From: Thomas Callaway
Sent: 04 June 2015 10:42
To: Planning.Responses
Subject: RE: Planning Consultation on: M/48/15/HH

Engineers comments in respect to surface water drainage:

APPLICATION M/48/15/HH

Description of Works: Single storey rear extension & loft conversion.

SITE PLAN 1:500

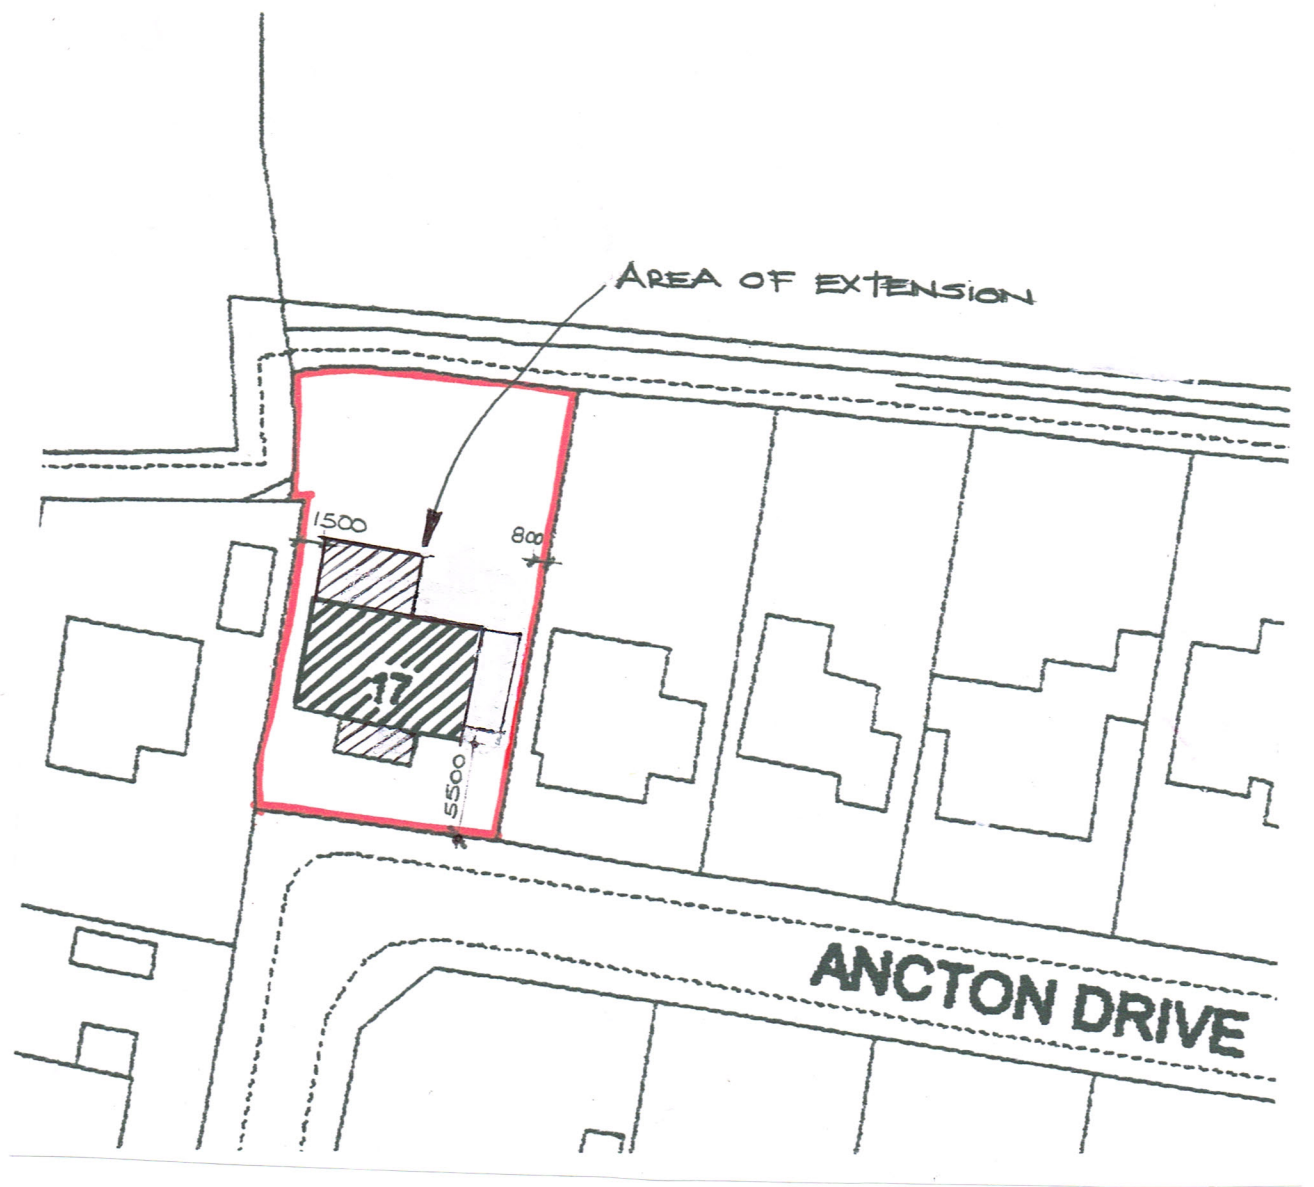
The applicant states that surface water will be discharged to existing surface water drainage. Infiltration should be investigated for the new extension.

Please apply standard conditions ENGD2A.

Infiltration rates for soakage structures are to be based on percolation tests undertaken in the winter period and at the location and depth of the proposed structures. The percolation tests must be carried out in accordance with BRE 365, CIRIA R156 or a similar approved method and cater for the 1 in 10 year storm between the invert of the entry pipe to the soakaway, and the base of the structure. It must also have provision to ensure that there is capacity in the system to contain below ground level the 1 in 100 year event plus 30% on stored volumes, as an allowance for climate change. Adequate freeboard must be provided between the base of the soakaway structure and the highest recorded annual groundwater level identified in that location.

Any SuDS or soakaway design must include adequate groundwater monitoring data to determine the highest winter groundwater table in support of the design. The applicant is advised to discuss the extent of groundwater monitoring with the Council's Engineers. Supplementary guidance notes are also enclosed for information.
